PLANNING APPLICATION REPORT**REF NO:** FP/121/11/**LOCATION:** Seacroft
Outram Road
Felpham Bognor Regis**PROPOSAL:** Two storey rear extension. Roof dormer to front. Re-submission following FP/6/11/**SITE AND SURROUNDINGS**

DESCRIPTION OF APPLICATION	This is a revised scheme following the refusal of FP/6/11. The current application substitutes a dormer window for the originally proposed two-storey extension to the front elevation. The proposed rear extension is unchanged from the original proposal.
SITE AREA	Approximately 154 square metres.
RESIDENTIAL DEVELOPMENT DEN	N/A
TOPOGRAPHY	Predominantly flat.
TREES	None affected by the proposed development.
BOUNDARY TREATMENT	The front boundary is open. Side boundaries to the front of the dwelling are marked by a low brick wall and approximately 1.5 metre high hedging to the east and west respectively. The rear garden is enclosed by approximately 1.8 metre high timber close boarded fencing.
SITE CHARACTERISTICS	The site is occupied by a two-storey semi-detached dwelling that has white painted render elevation walls and a tiled, gable roof. Single-storey lean-to extensions have been added to the front and rear.

Proposed Front Elevation

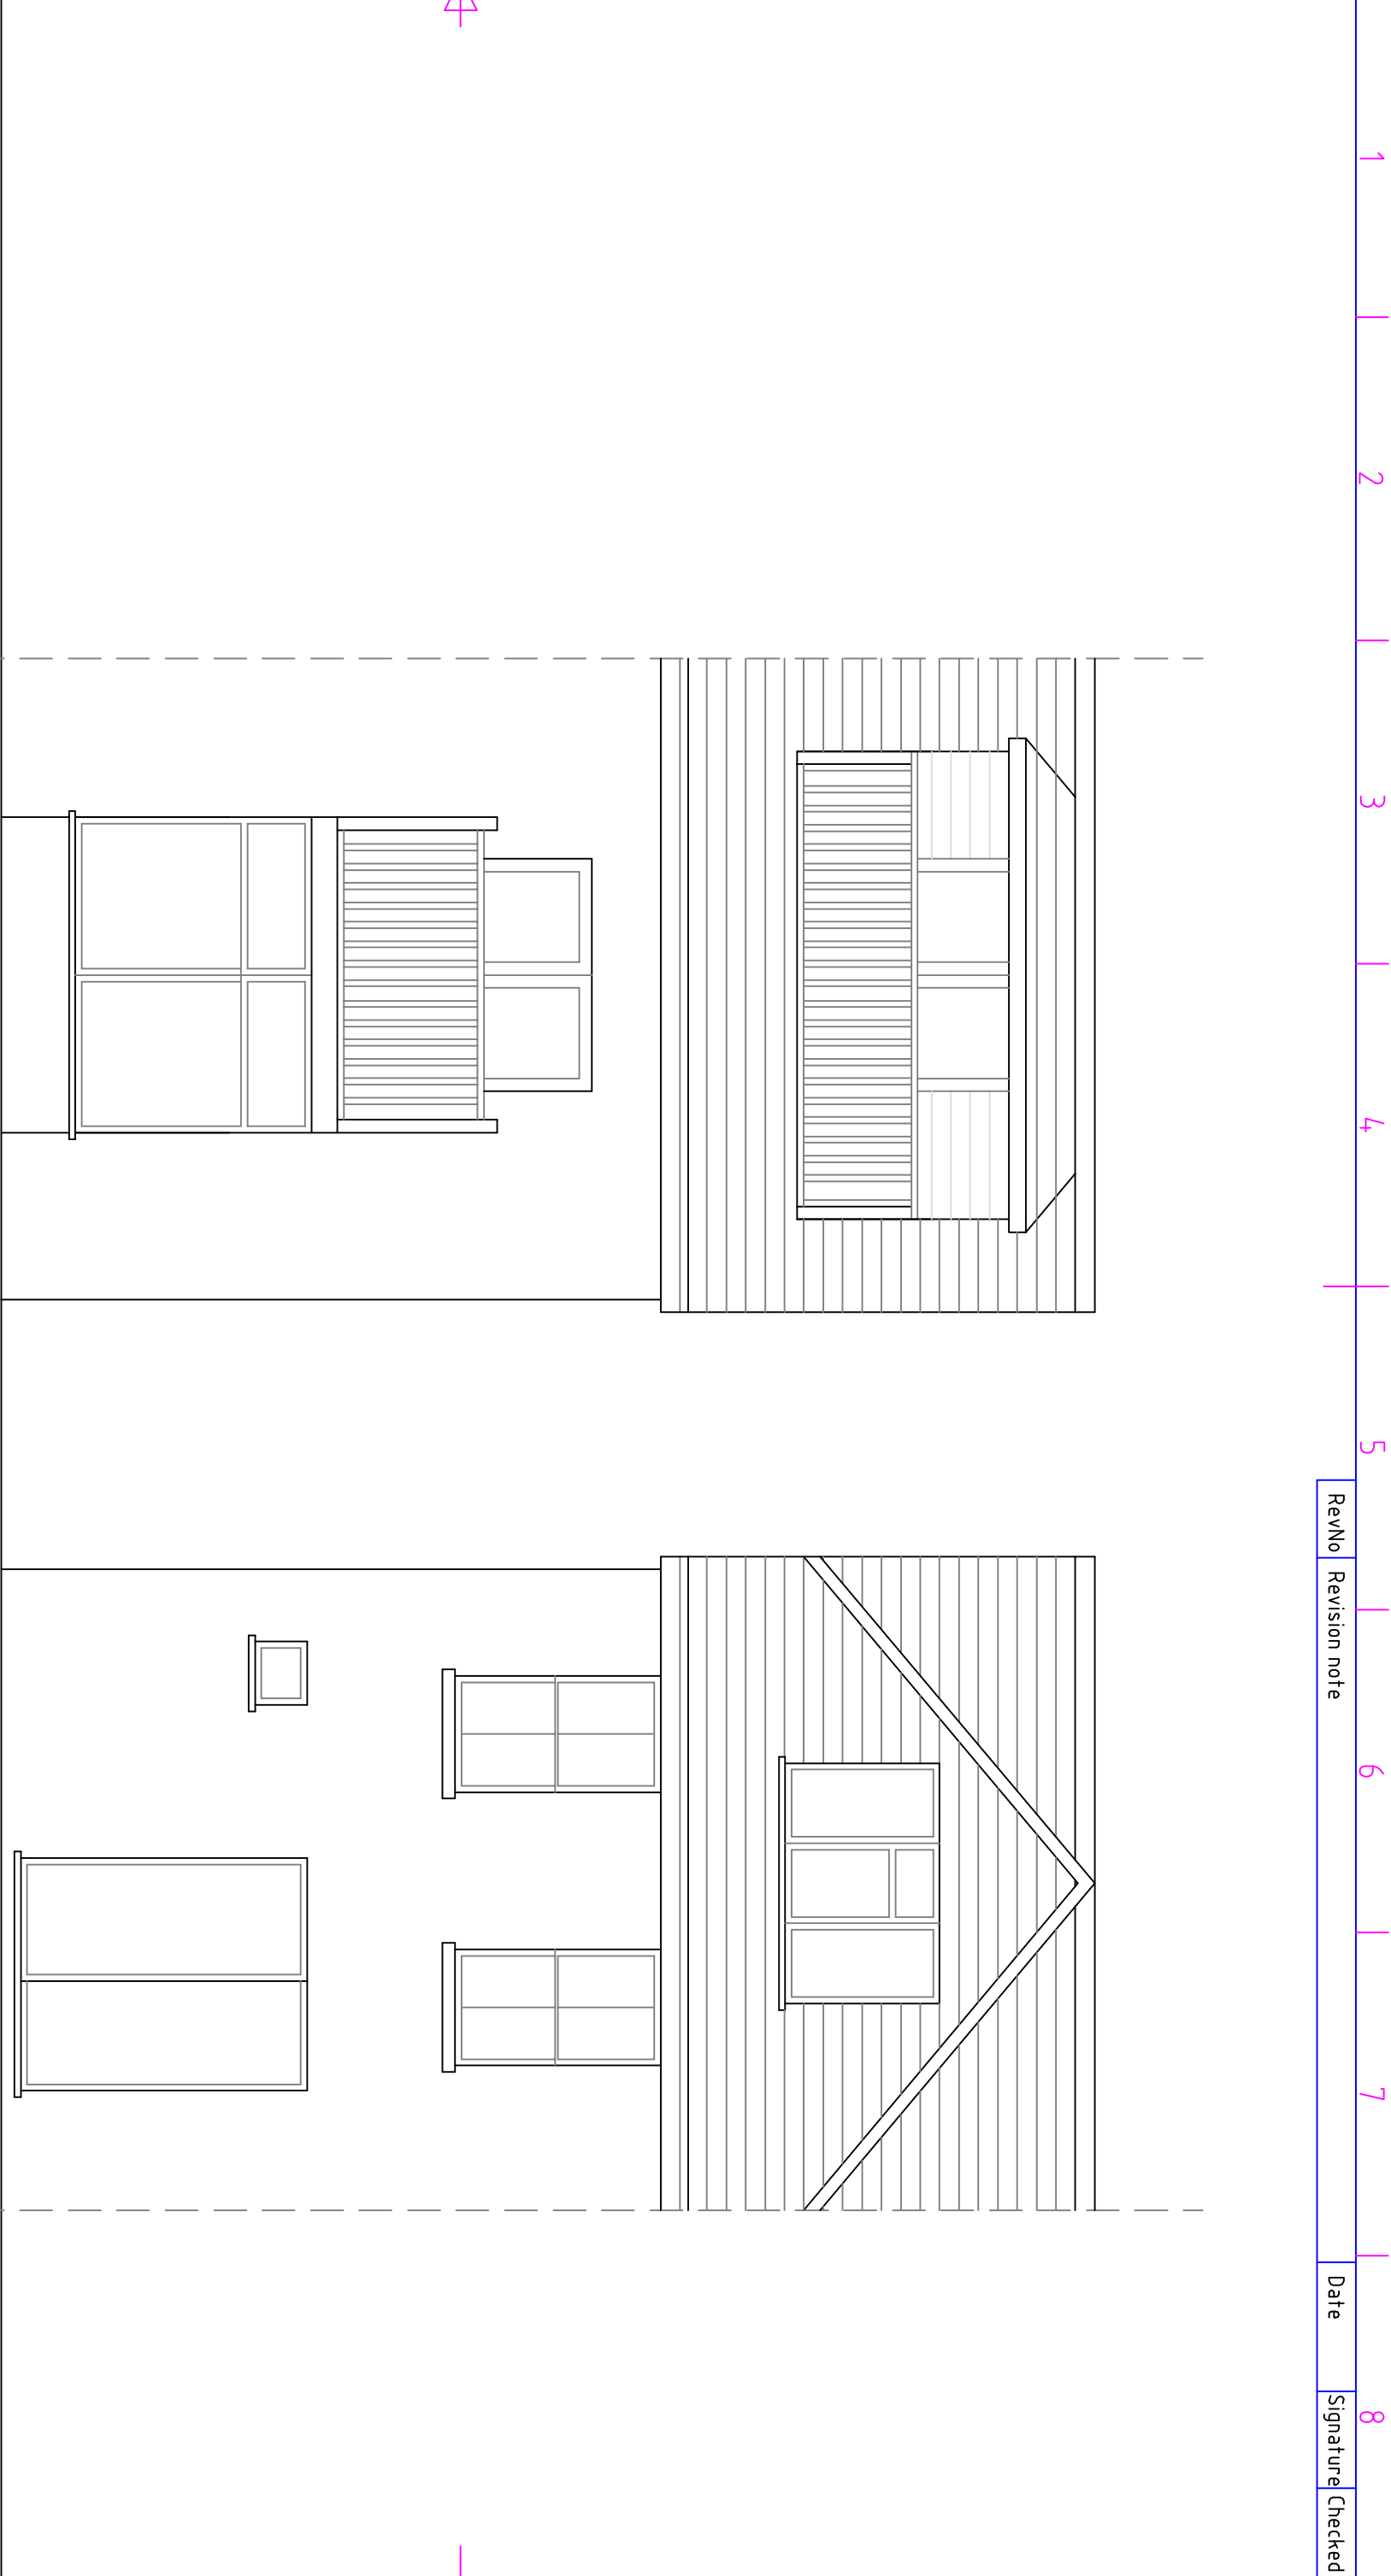
DESIGN & SCALE: The proposed works are considered to relate sympathetically towards the existing building in terms of design and scale. The proposed rear extension has a matching ridge height to that of the existing roof, ensuring visual integration with it, whilst it has a smaller footprint than the existing dwelling, so as not to visually dominate it. The gable end design of the extension will also compliment the gable endings of the existing building. The proposed dormer is stepped

up from the eaves height of the front roof slope and stepped in from the roof edges, to prevent it from appearing overly dominant.

With regards to the proposed front balcony, it is noted that, as shown in the plans, this may offer views downwards towards the front balcony at No. 2 Outram Road. It is considered this can be mitigated by conditioning any approval given for the application to require that obscure screening of 1.8 metres in height is erected to the sides of the balcony in order to obstruct these views.

- 3 Development shall not be commenced until details of satisfactory 1.8 metre high obscure screening, to be employed on the eastern and western balcony edges, are submitted to and approved by the Local Planning Authority. The balcony shall not be used until such screening has been erected and it shall remain in position in perpetuity from that time.

Proposed Side Elevation

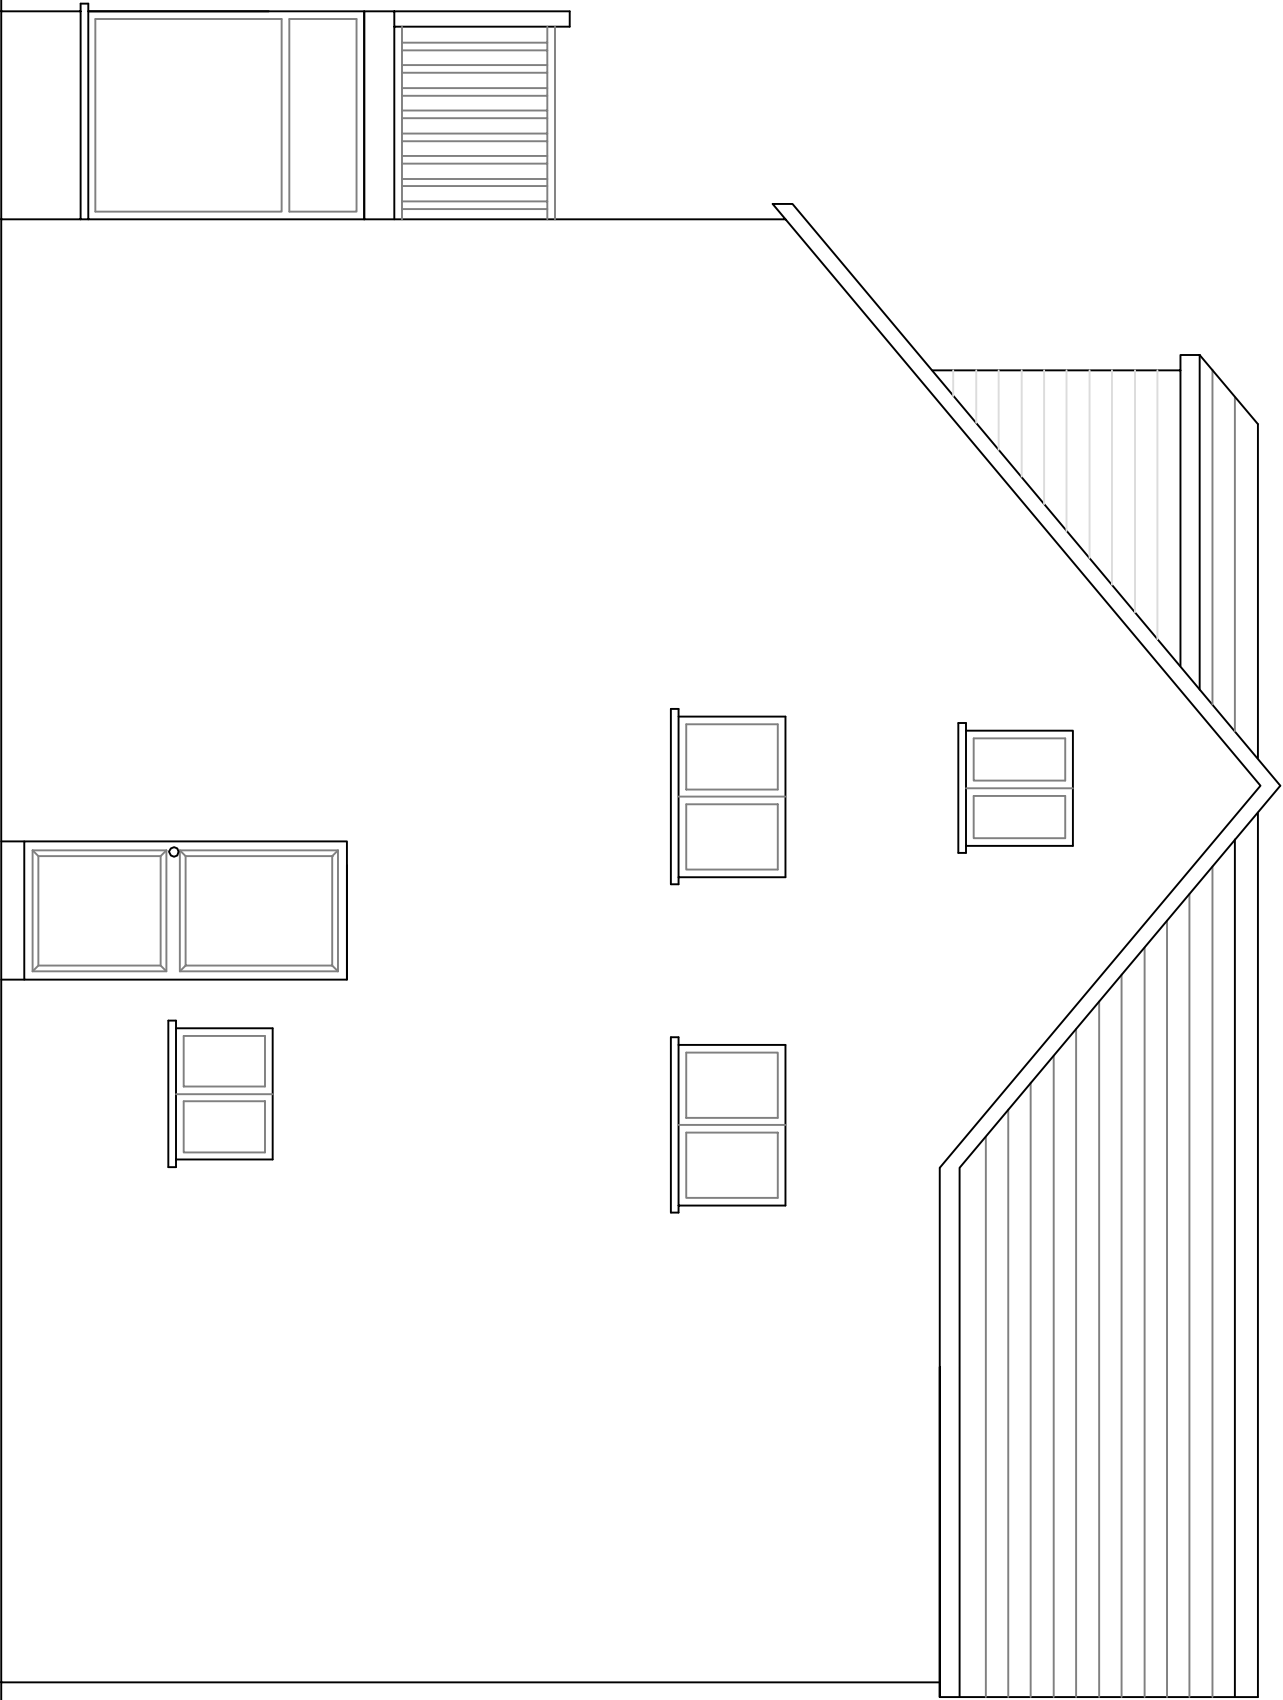
RESIDENTIAL AMENITIES: The proposed rear extension will be positioned in line with the flank walls of existing single and two-storey extensions at the neighbouring property, No. 2 Outram Road and the flank walls of buildings at 'Outram Lodge' to the west and east respectively. They will not project any further to the rear than these extensions and will not obstruct any 45 degree sight lines taken from primary windows of the neighbouring property. It is therefore considered that they will not appear overbearing or cause overshadowing towards this property. Further, it is considered that the extension is a sufficient distance from properties on Clyde Road, that back onto the site to prevent any harmful overbearing, overlooking or overshadowing impact.

All new ground floor windows will have views towards neighbouring properties interrupted by existing site boundary treatment whilst the proposed first floor windows to the side will look towards flank walls and roof slopes at 'Outram Lodge' and the proposed first floor window on the rear elevation will face towards the far end of the site and be a sufficient distance from properties backing onto it to prevent unacceptable visual intrusion.

Item ref	Quantity	Title/Name, designation, material, dimension etc			Article No./Reference
Designed by	Checked by	Approved by - date	File name	Date	Scale
JD				Sept 2010	1:200

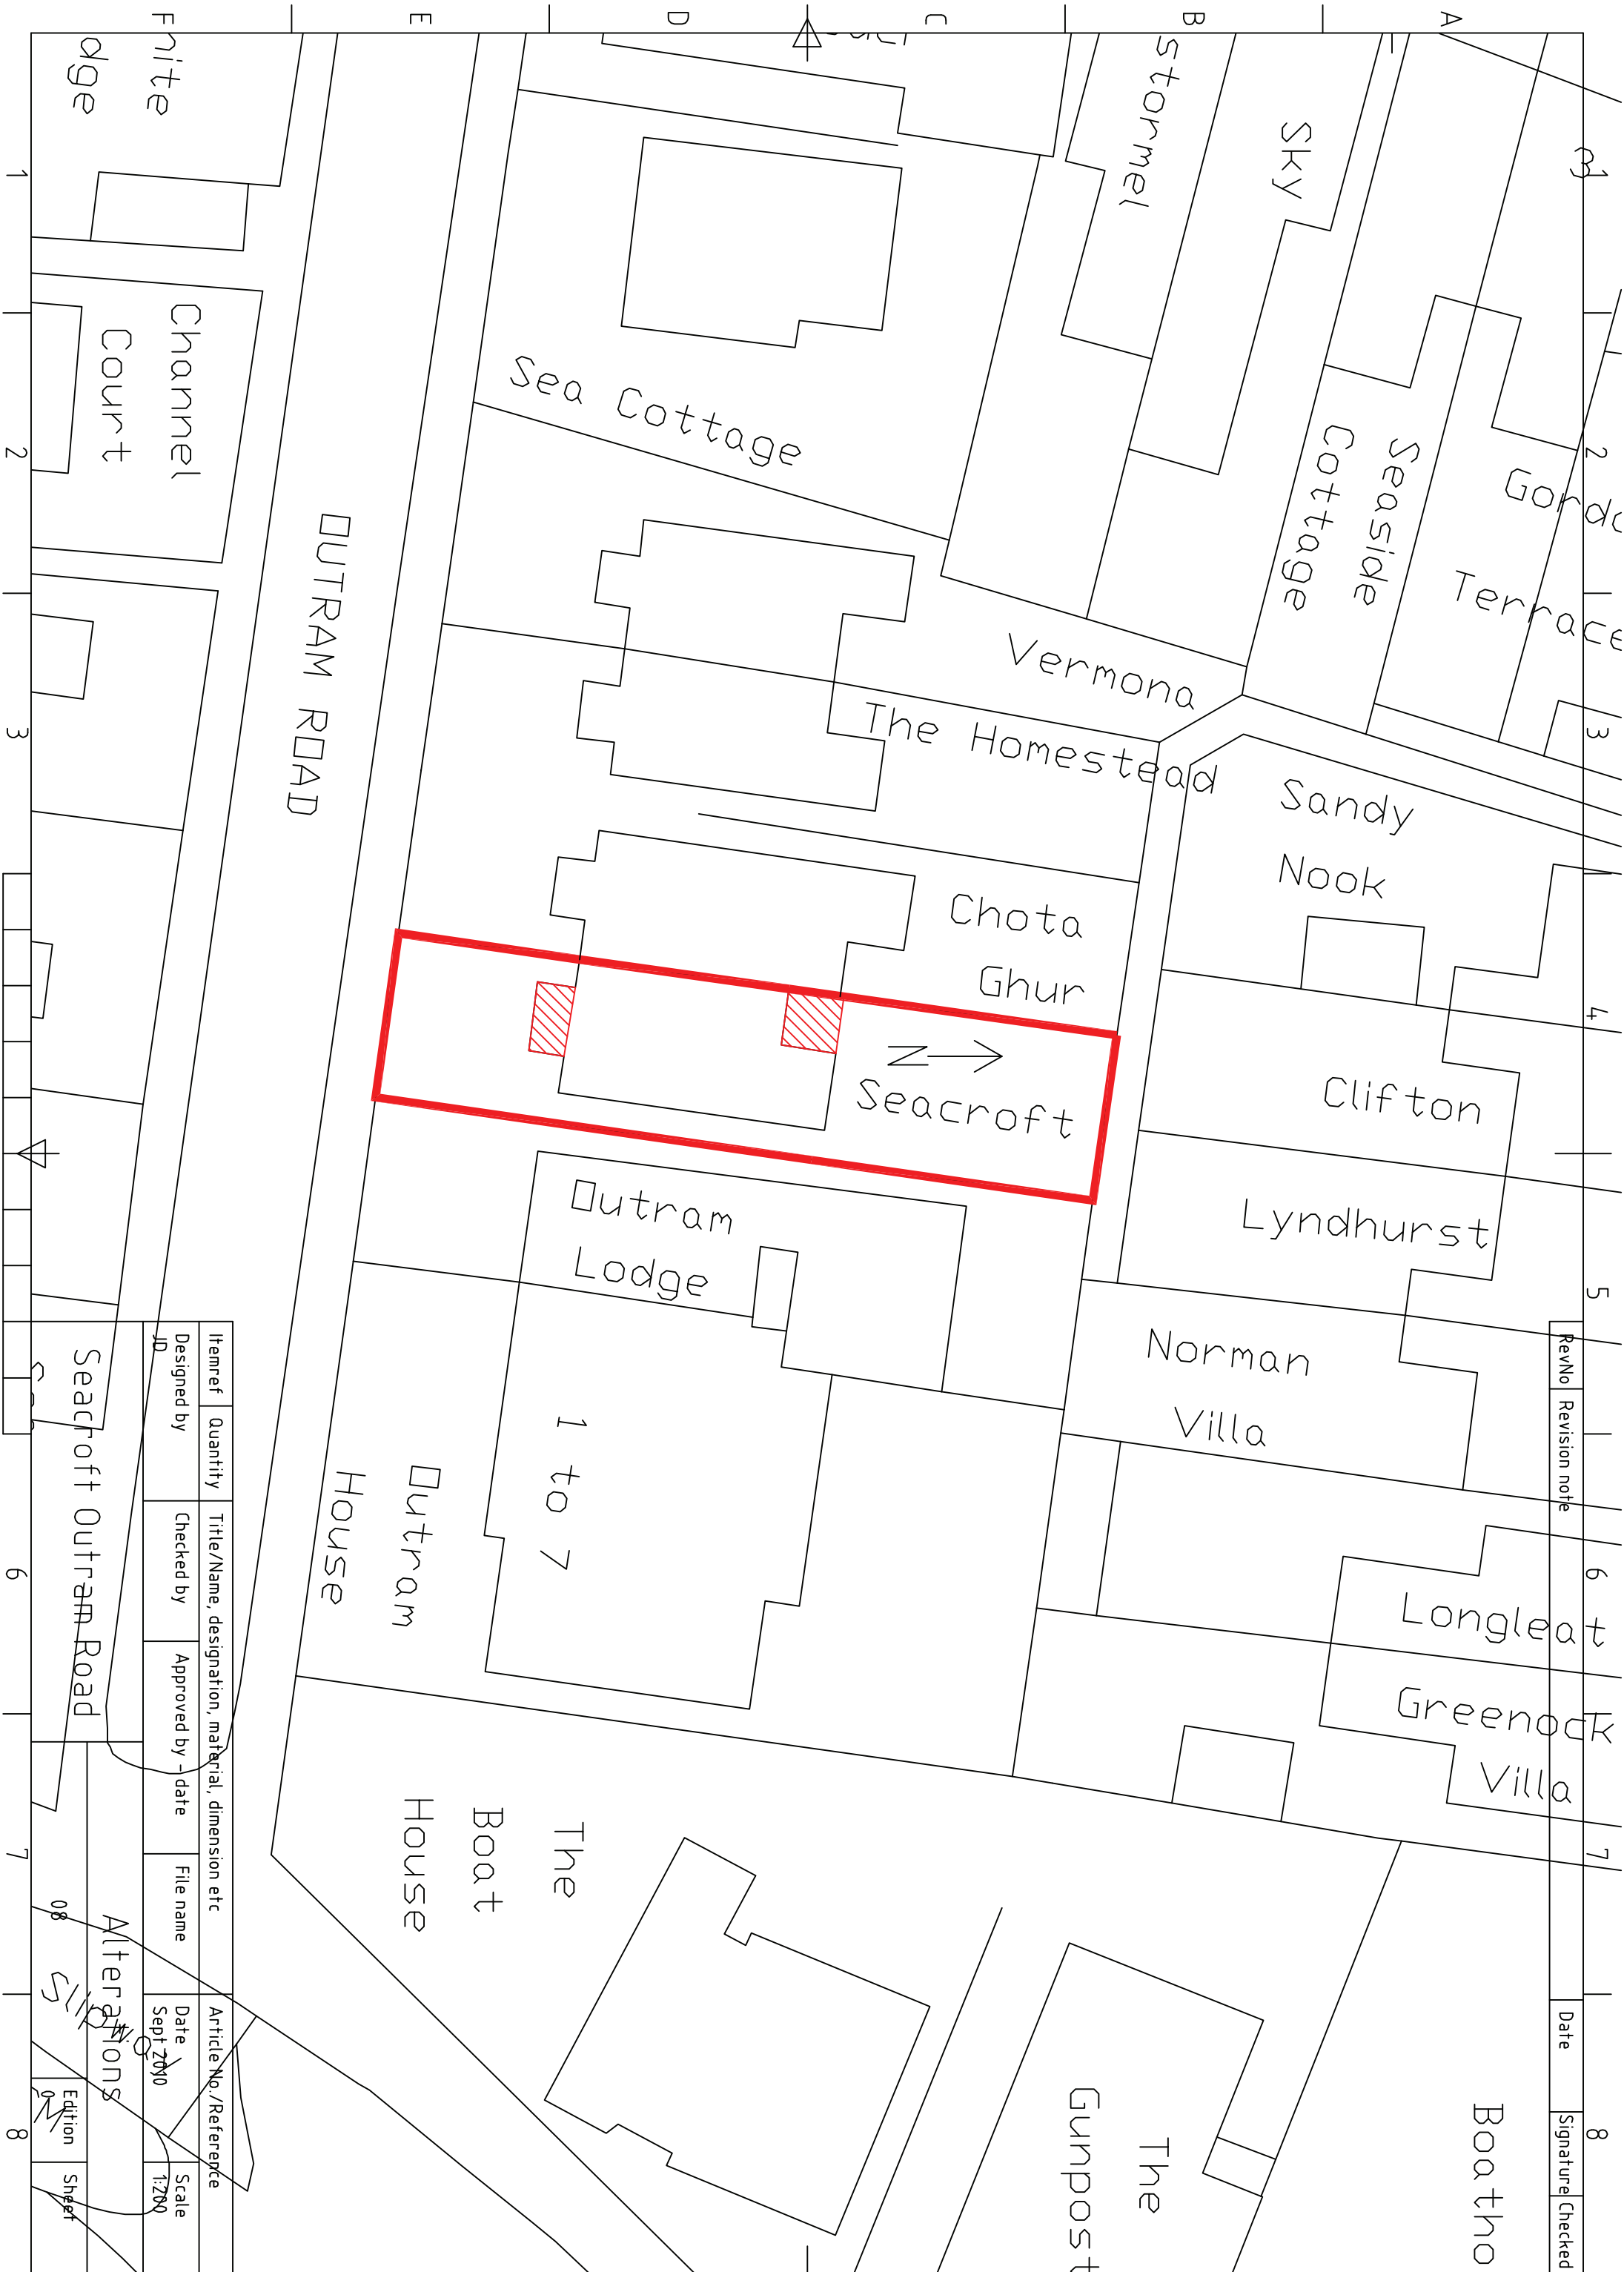
Objection: The site plan is misleading, a cross hatched section is shown to the rear but it is unclear what it is. A full explanation is required as to what advice was given by the Case Officer for this resubmission as the Committee cannot see what has changed to resolve the refusal reasons for FP/6/11.
